CITY OF PORTLAND, MAINE

October 11, 2017

Project Name: Onejoy Place Condominium - Twelve Unit Residential Building
Project ID: 2017-103 (Subdivision and Site Plan)
2017-128 (Conditional Use Inclusionary Zoning)
Address: 1 Joy Place CBL: 045 E049001
Applicant: Onejoy Place LLC
Planner: Jean Fraser

SITE PLAN
SCALE: 1" = 10'-0"

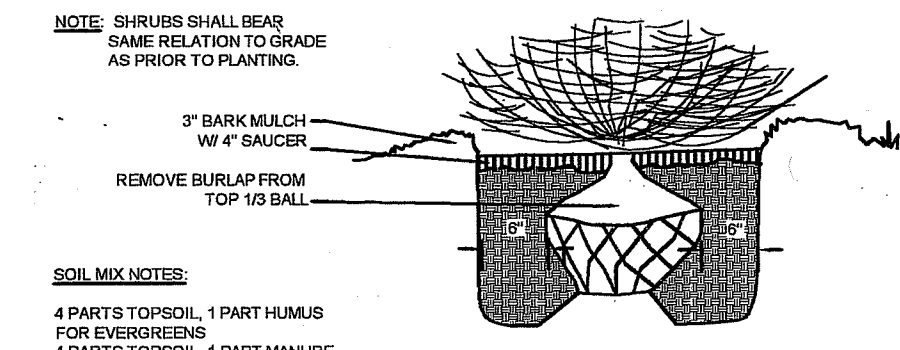
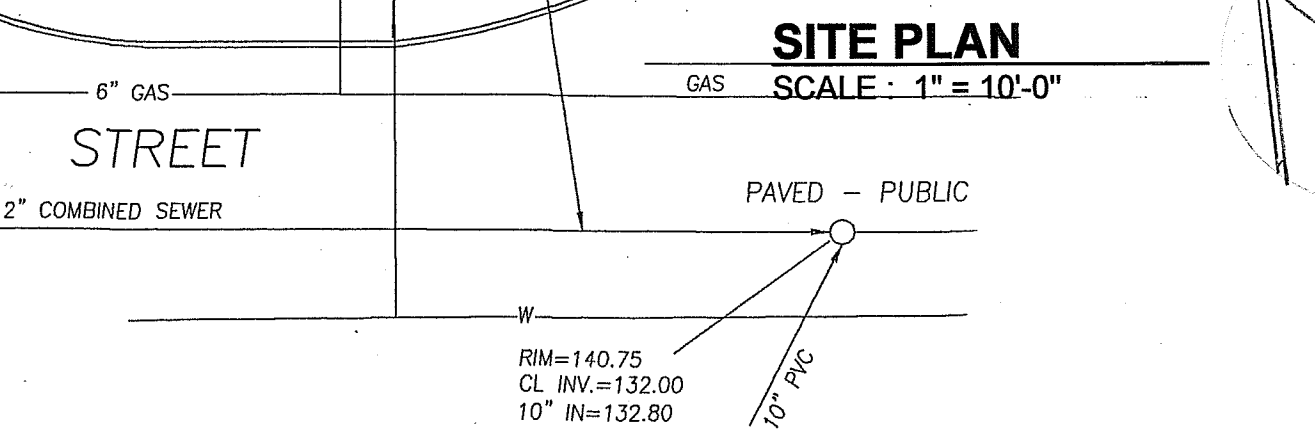
- v. That the Landscaping Plan shall be revised, for review and approval by the City Arborist and Planning Authority prior to the issuance of a building permit, to replace the Amur Maple with a species suggested by the City Arborist in his comments dated 9.21.2017; and

The project does have landscape challenges due to its unique site location and lack of street frontage. One suggestive comment would be to find a substitution for the Amur Maple as they tend to show up on the invasive plant list. Other suggestions might include 'Cornus mas', Hop Hornbeam, Cornelian Cherry Dogwood.

BRICK DRIVEWAY APRON

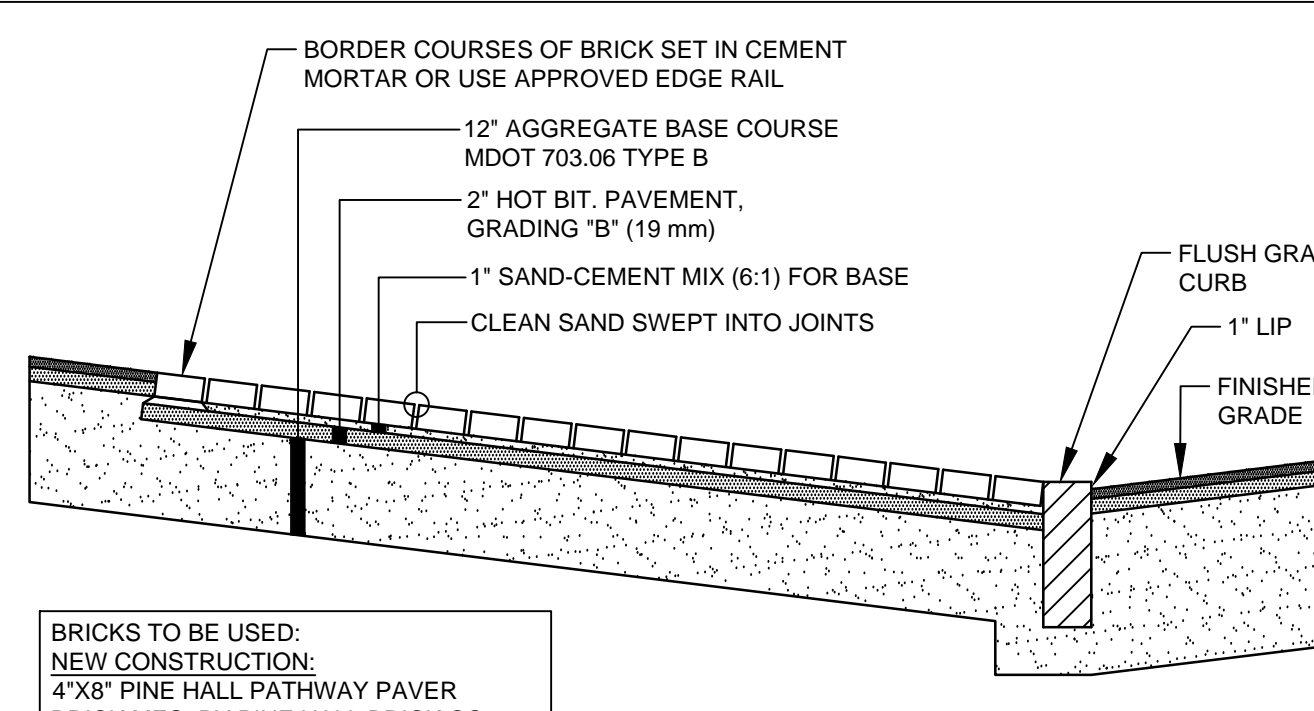
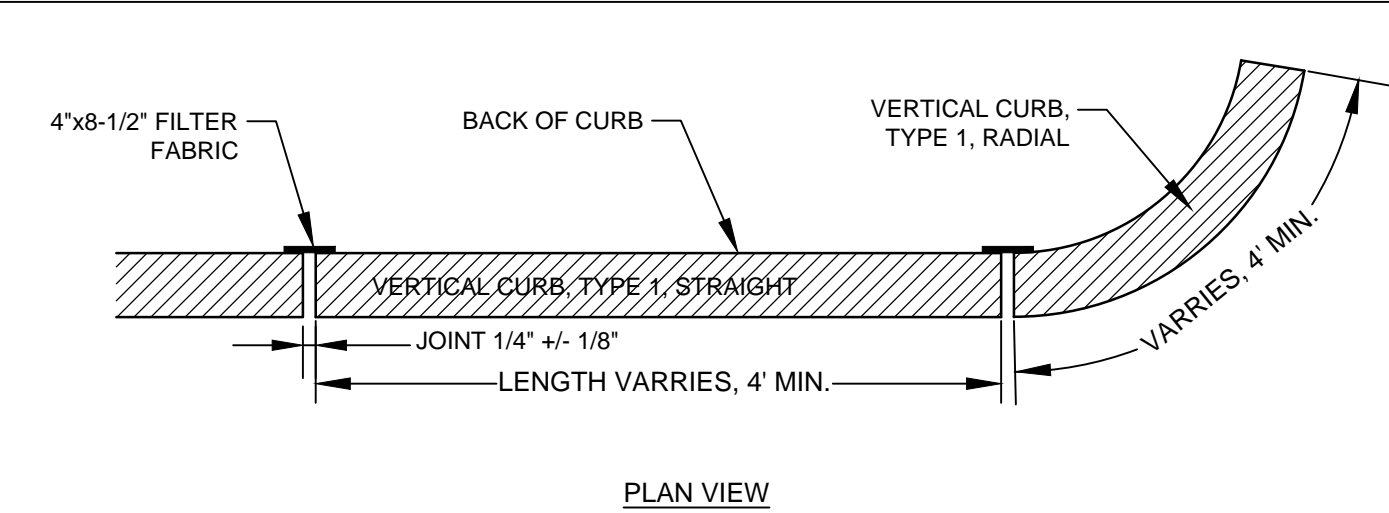
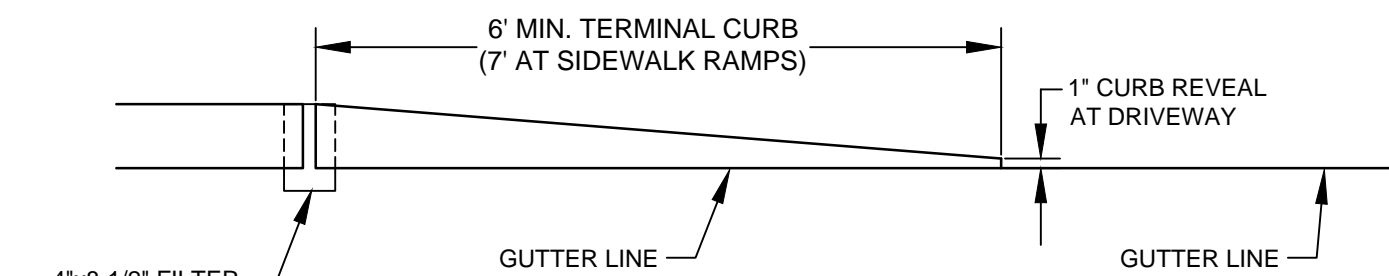
- viii. That the design of the apron and associated sidewalk shall meet Technical Standards and conform to the design detail provided in the final submissions (2% maximum cross-slope); and

- The driveway apron shall be designed to provide a maximum cross-slope of 2 percent along the pedestrian accessibility route.

Status: The applicant has noted in writing that a 2 percent pedestrian accessibility route cannot be provided along Brackett Street in the Joy Place driveway apron area. The applicant has provided a driveway design detail that specifies a maximum cross-slope of 2 percent for the driveway apron. A condition of approval should reinforce the requirement that the driveway apron shall conform to the design detail provided (2% maximum cross-slope).
